Re: Observation on Strategic Infrastructure Development application for the proposed Littleton Wind Farm, Co. Tipperary - Case Reference: PCX92.311587

Applicant: Littleton Wind Farm DAC (a joint venture of SSE Renewables and Bord na Móna Powergen Ltd)

I am writing to formally object to the above proposed Strategic Infrastructure Development, comprising 11 no. wind turbines (200m blade tip height), an onsite 110kV electrical substation, a permanent meteorological mast, an onsite borrow pit, peat and spoil deposition areas, internal access tracks, recreational amenity trails and all associated works at Littleton, Longfordpass, Lanespark, Ballybeg and Derryvella Bogs, Co. Tipperary, together with the accompanying Environmental Impact Assessment Report (EIAR) and Natura Impact Statement (NIS).

<b>TITLE:</b>	Windfarms within 20km
<b>PROJECT:</b>	Littleton Windfarm
<b>FIGURE NO.:</b>	4.6
<b>CLIENT:</b>	Littleton Wind Farm DAC
<b>SCALE:</b> 1:200,000	<b>REVISION:</b> 0
<b>DATE:</b> 30/04/2026	<b>PAGE SIZE:</b> A3

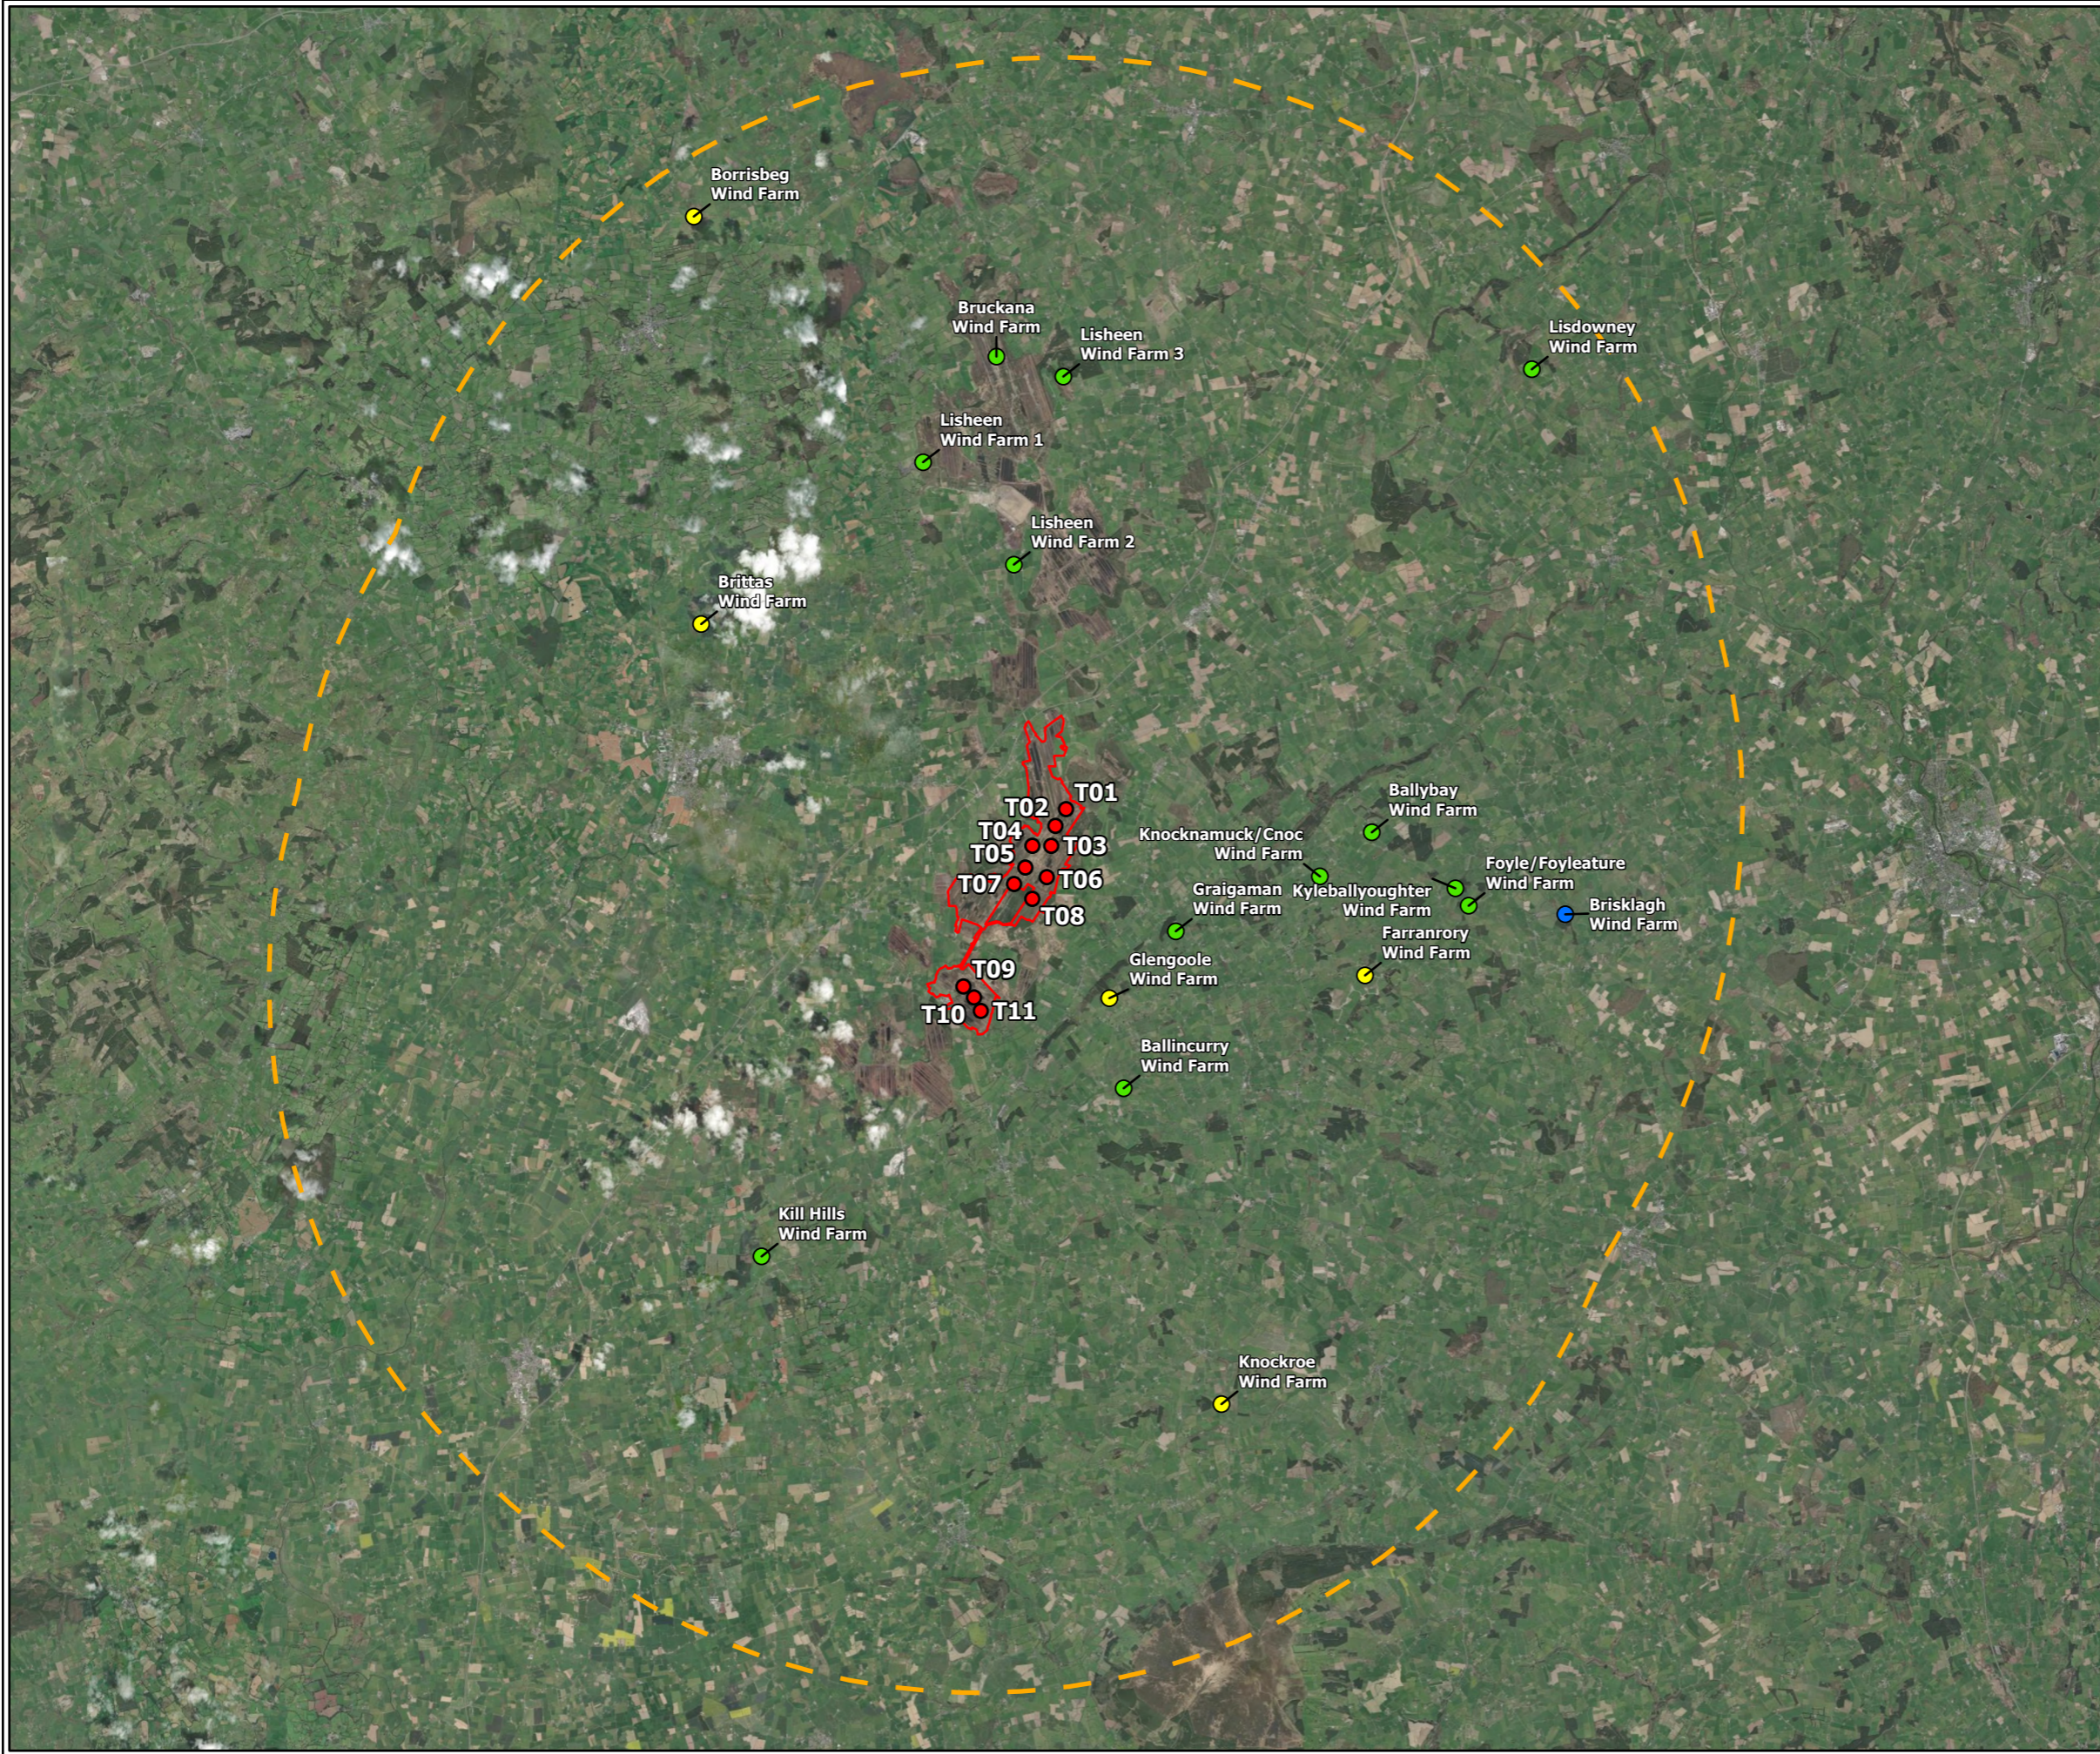
- This area is already saturated with wind farms. The applicant's own figures (Chapter 5, Table 5-4) show 11 wind farms already operating within 20km - around 89 turbines in total. The closest are Gurteen (4.2km east), Ballincurry (4.9km south-east) and Knocknamuck/Cnoc (7.9km east). A further 3 wind farms (38 more turbines) are already consented but not built, and one more (Brisklagh, 7 turbines) is awaiting a decision. Once these are built, Littleton would be the 17th wind farm within 20km, adding to well over 130 existing and approved turbines. The cumulative visual dominance of turbines from every direction has not been properly weighed.

- The applicant's cumulative landscape and visual assessment (Section 13.9) uses non-statutory Scottish (NatureScot) guidance - by its own admission, because "there is no current guidance document in Ireland" for this. With no settled Irish methodology, the Commission should scrutinise this assessment carefully, especially given how many wind farms already exist or are proposed within the 20km study area (Figure 4.06).

Client:			
Drawing Status:	FOR PLANNING		
Project Title:	LITTLETON WIND FARM		
Drawing Title:	FIGURE 12-1: SHADOW FLICKER STUDY AREA AND RECEPTORS		
Scale:	1:40,000	Original Size:	A3
Drawing Number:	IE00402-002

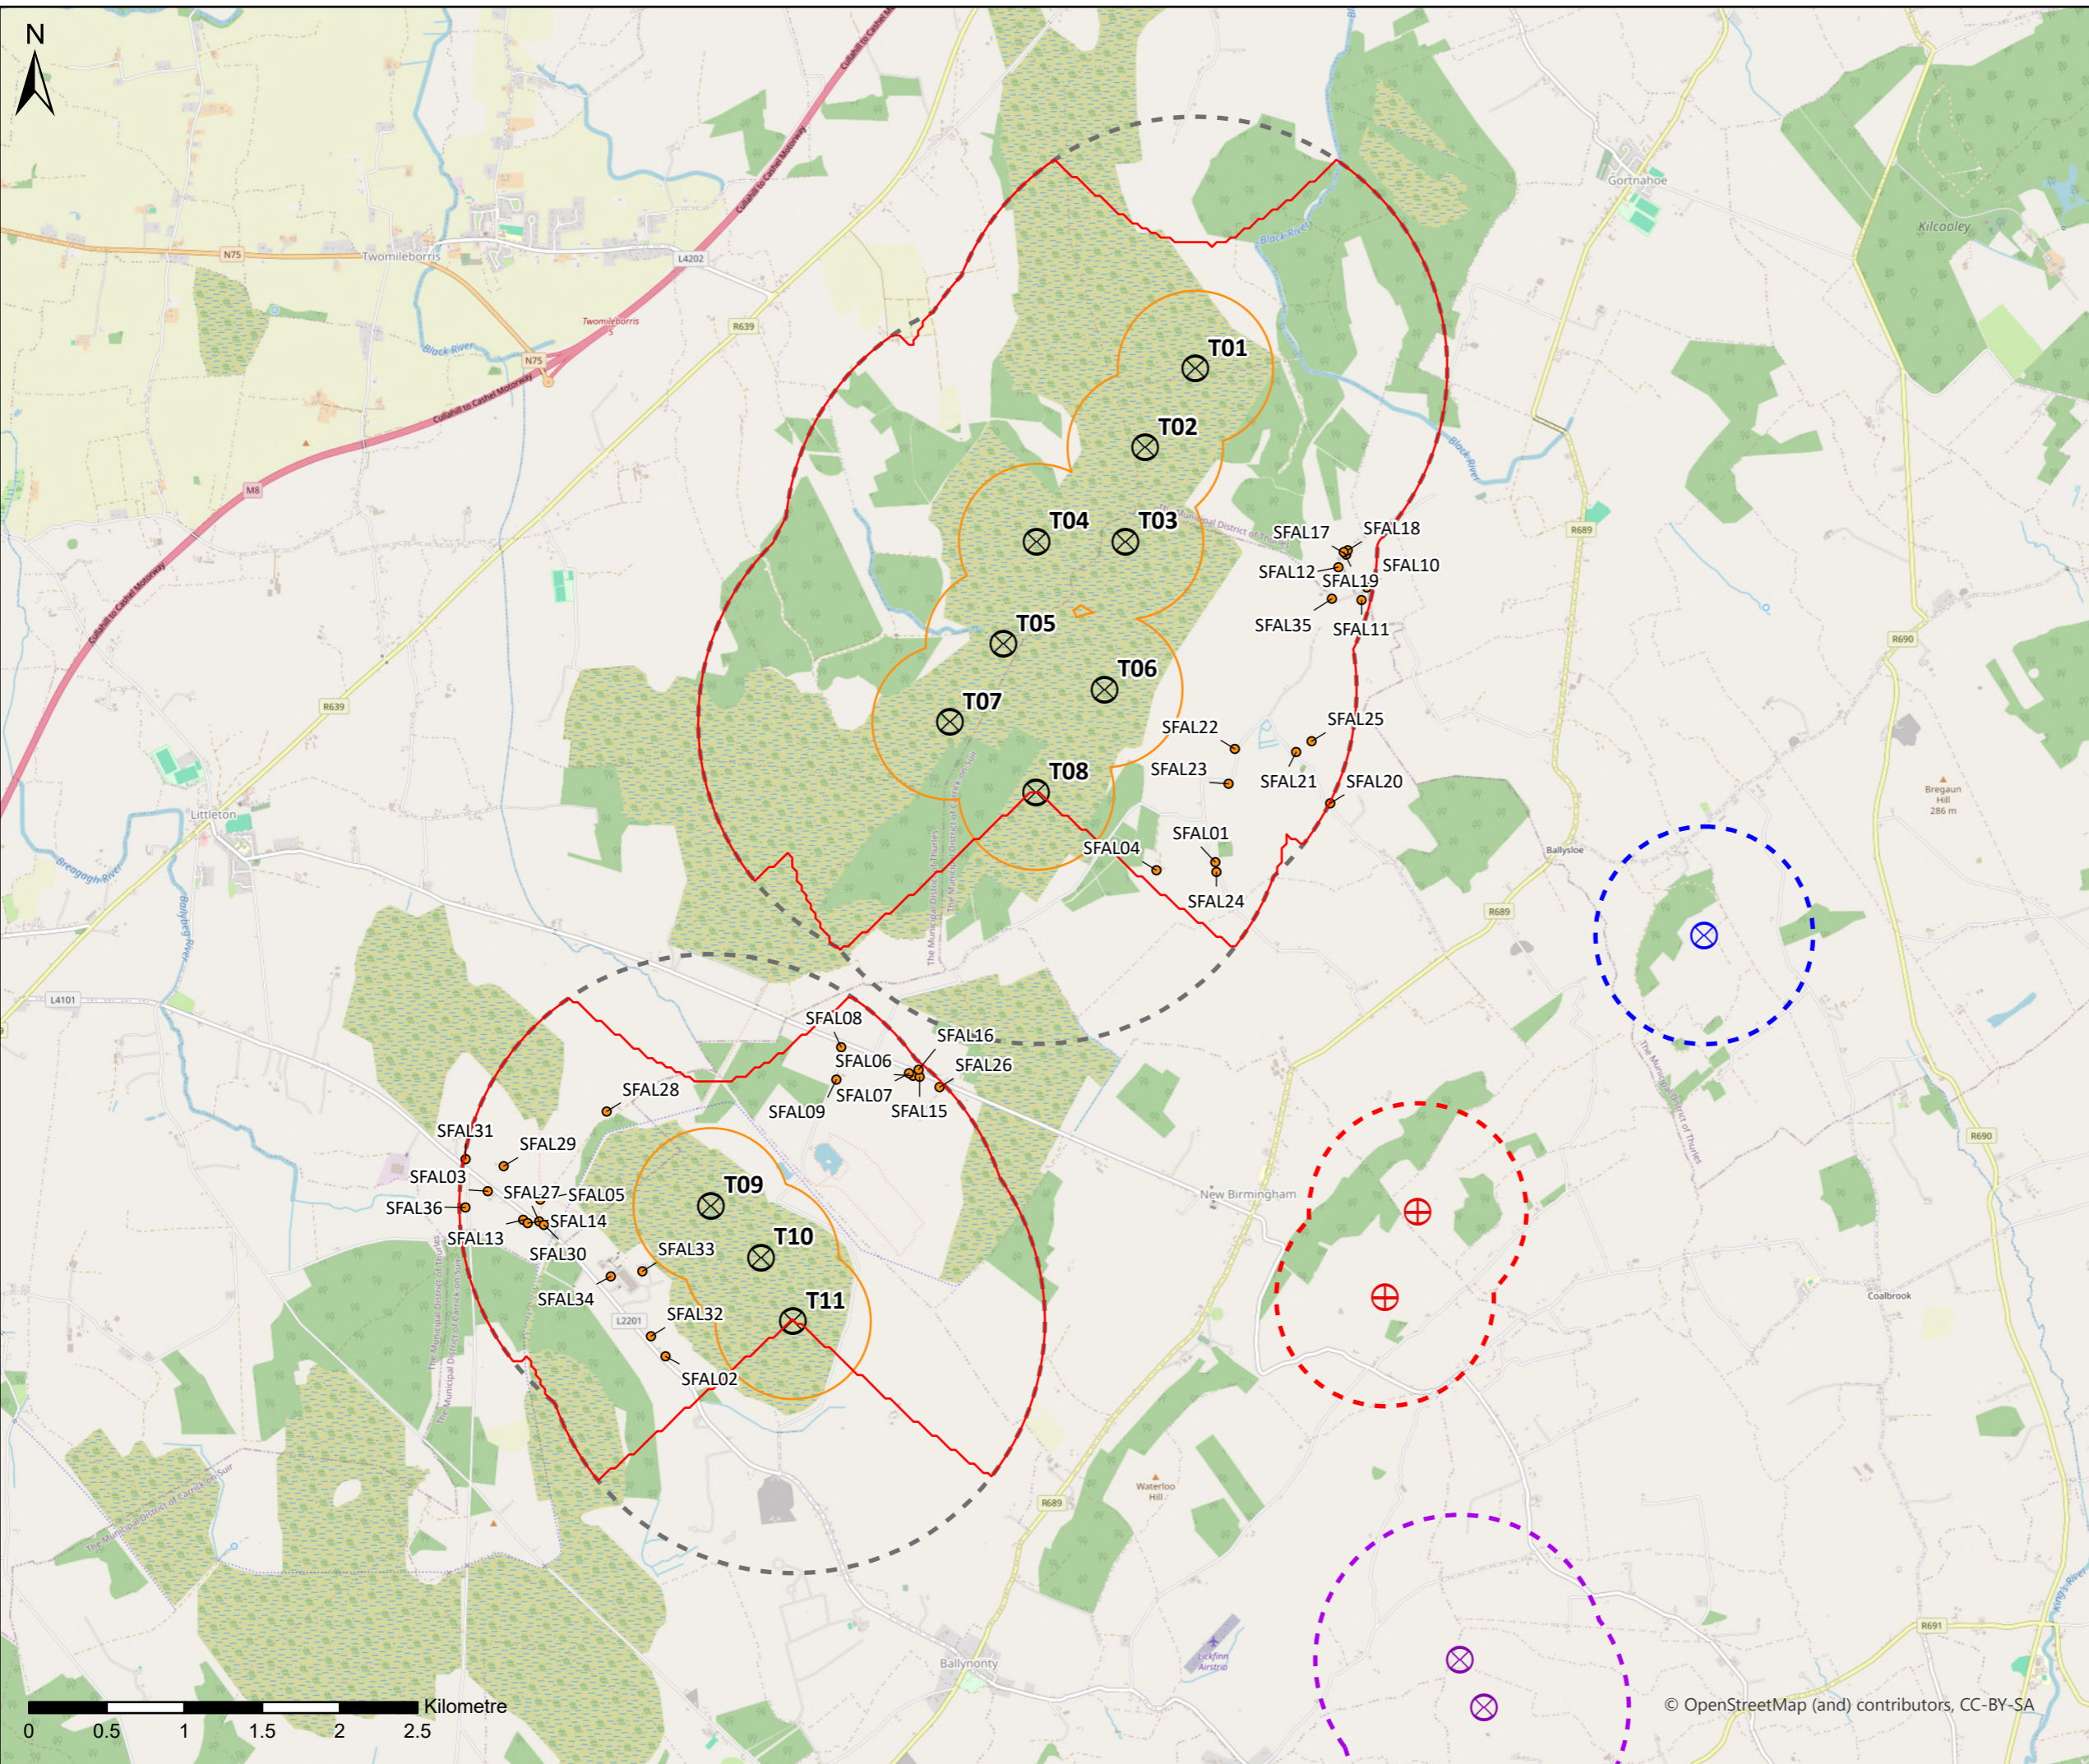
- Shadow flicker: the applicant's own Chapter 12 modelling shows that, in a worst-case scenario, 16 of 36 receptors would exceed the 30-hours-per-year guideline, and 18 would exceed 30 minutes per day. One receptor (SFAL22) is modelled at almost 76 hours a year. The applicant only avoids a "significant effect" finding by applying a sunshine-hours correction to the annual figure - but admits this correction cannot be applied to the daily 30-minute limit. So the 18-receptor daily exceedance is not actually resolved by that adjustment. The proposed fix is reactive, not preventative: turbines only shut down after a resident reports flicker and it is validated against the model, rather than being designed out from the start, as the Draft 2019 Guidelines' "zero shadow flicker" policy recommends. Residents should not have to detect, report and wait for validation of an impact the applicant's own modelling already predicts.
